PRE-REGISTRATION CHECK SHEET – TO BE COMPLETED BY DUTY OFFICER AS APPROPRIATE

<p>UPRN: 000120053558 (If NO UPRN – Admin to contact Technician)</p> <p>Site Address: <i>(Leave blank if no UPRN)</i></p> <p>11 Redcroft Road, Danderhall EH22 1FQ</p>	<p>Description of Proposal:</p> <p>Extension to dwellinghouse and extension to garage</p>
------------------------------------------------------------------------------------------------------------------------------------------------------------------------------------------------------------------------------------------------------------	--------------------------------------------------------------------------------------------------

| <input checked="" type="checkbox"/> | Inadequate Plans | The following additional plans are required: |

ELEVATIONS.

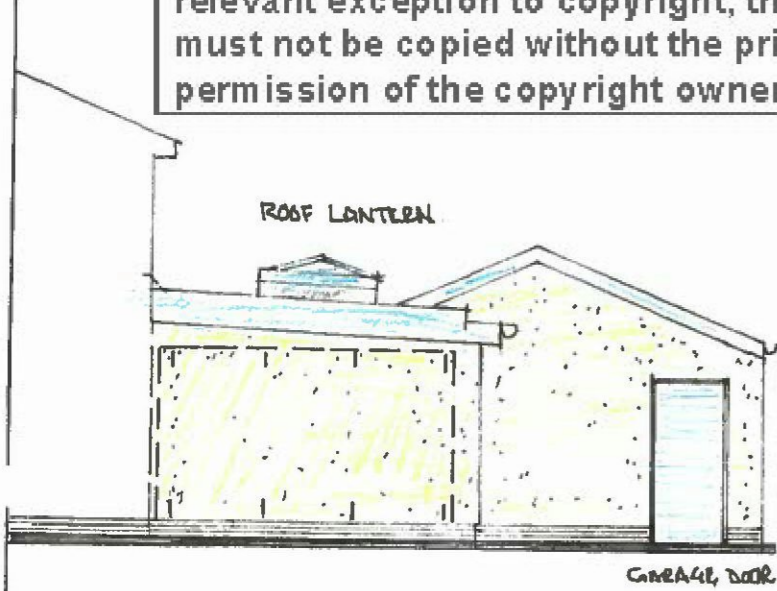
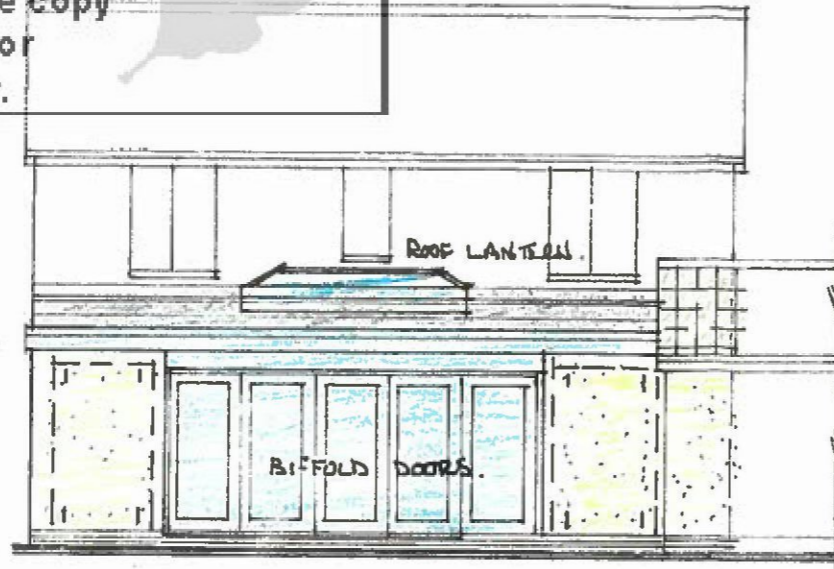
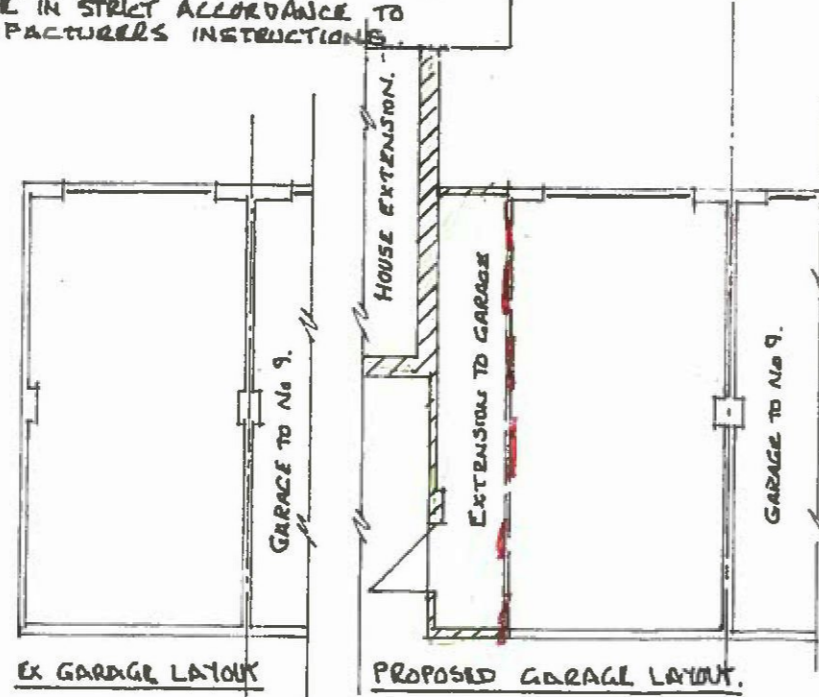
- Existing and proposed floor plan for the garage;
- Unobscured existing and proposed elevation plans of the garage and garage extension;
- The site/location plan does not match up with the proposed ground floor plan – please amend;

SITE / LOCATION PLAN

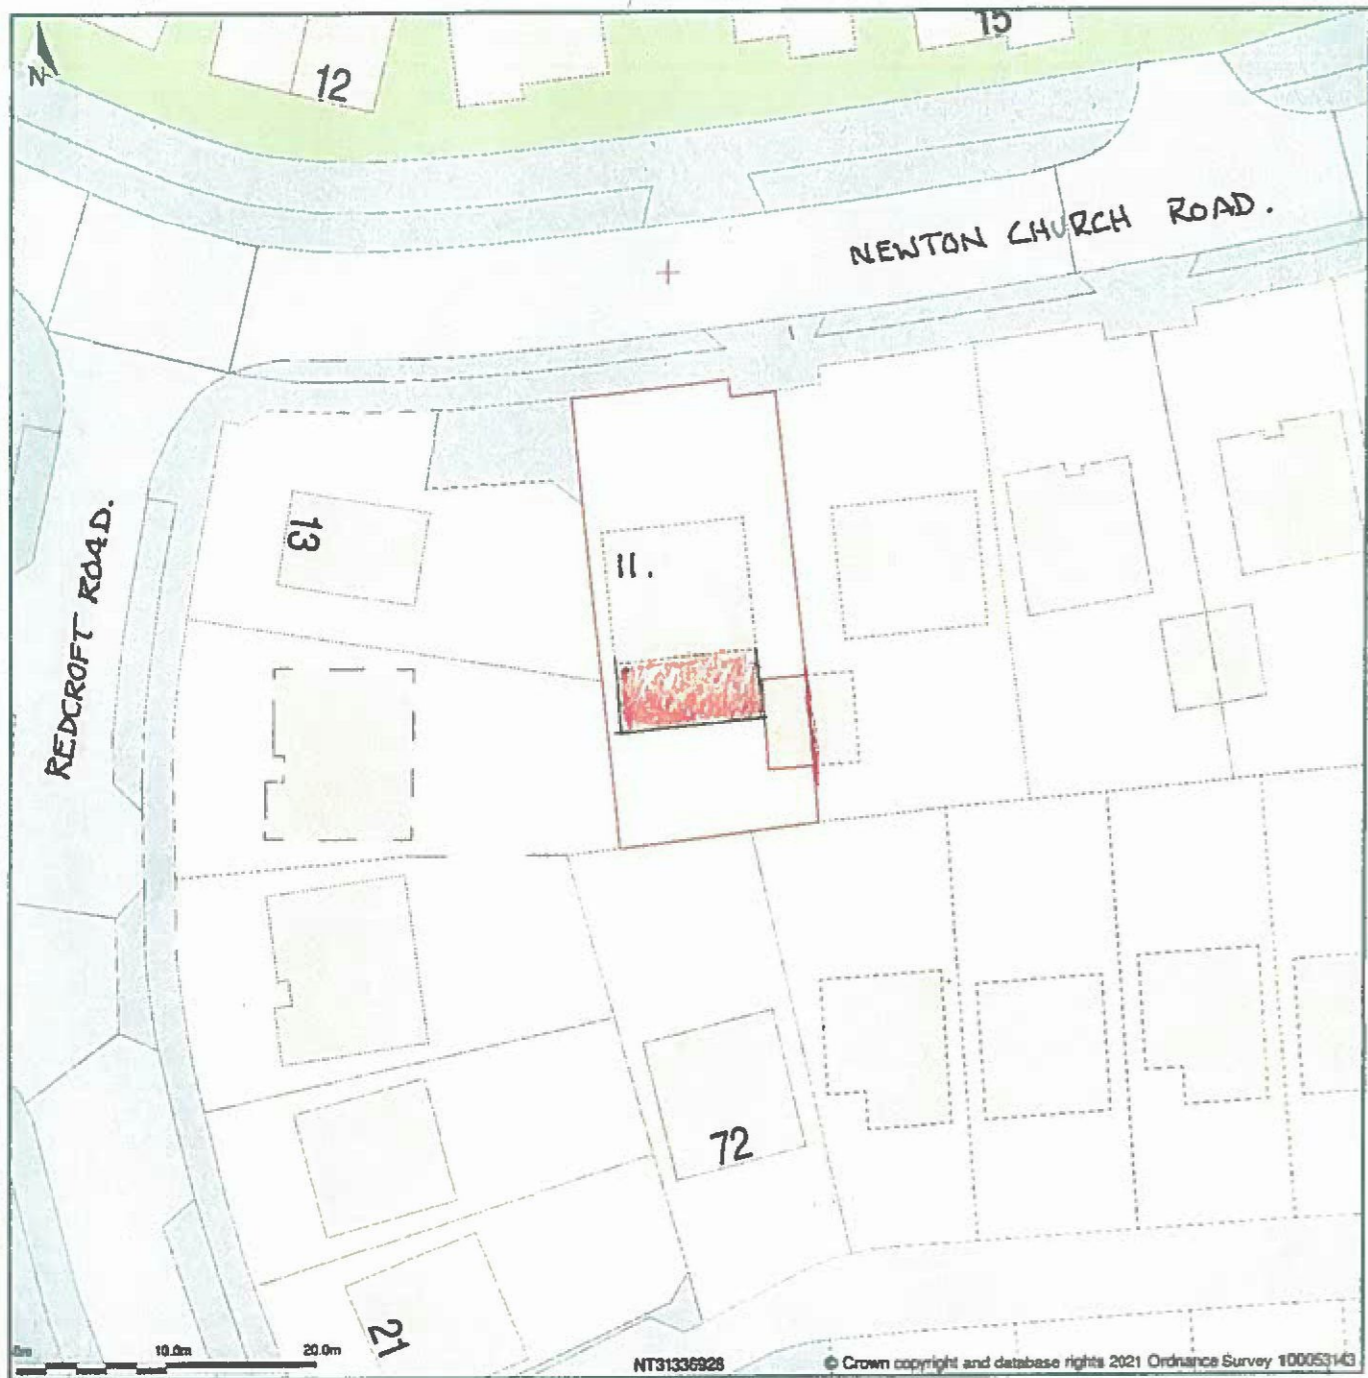
- It is noted that the proposed extensions to the dwellinghouse and garage may be permitted development. However, it is unclear from the submitted plans. To allow me to determine whether planning permission is required I would be grateful if you could submit a proposed site plan to show areas of hard and non hard surface and any areas of development within the rear garden.
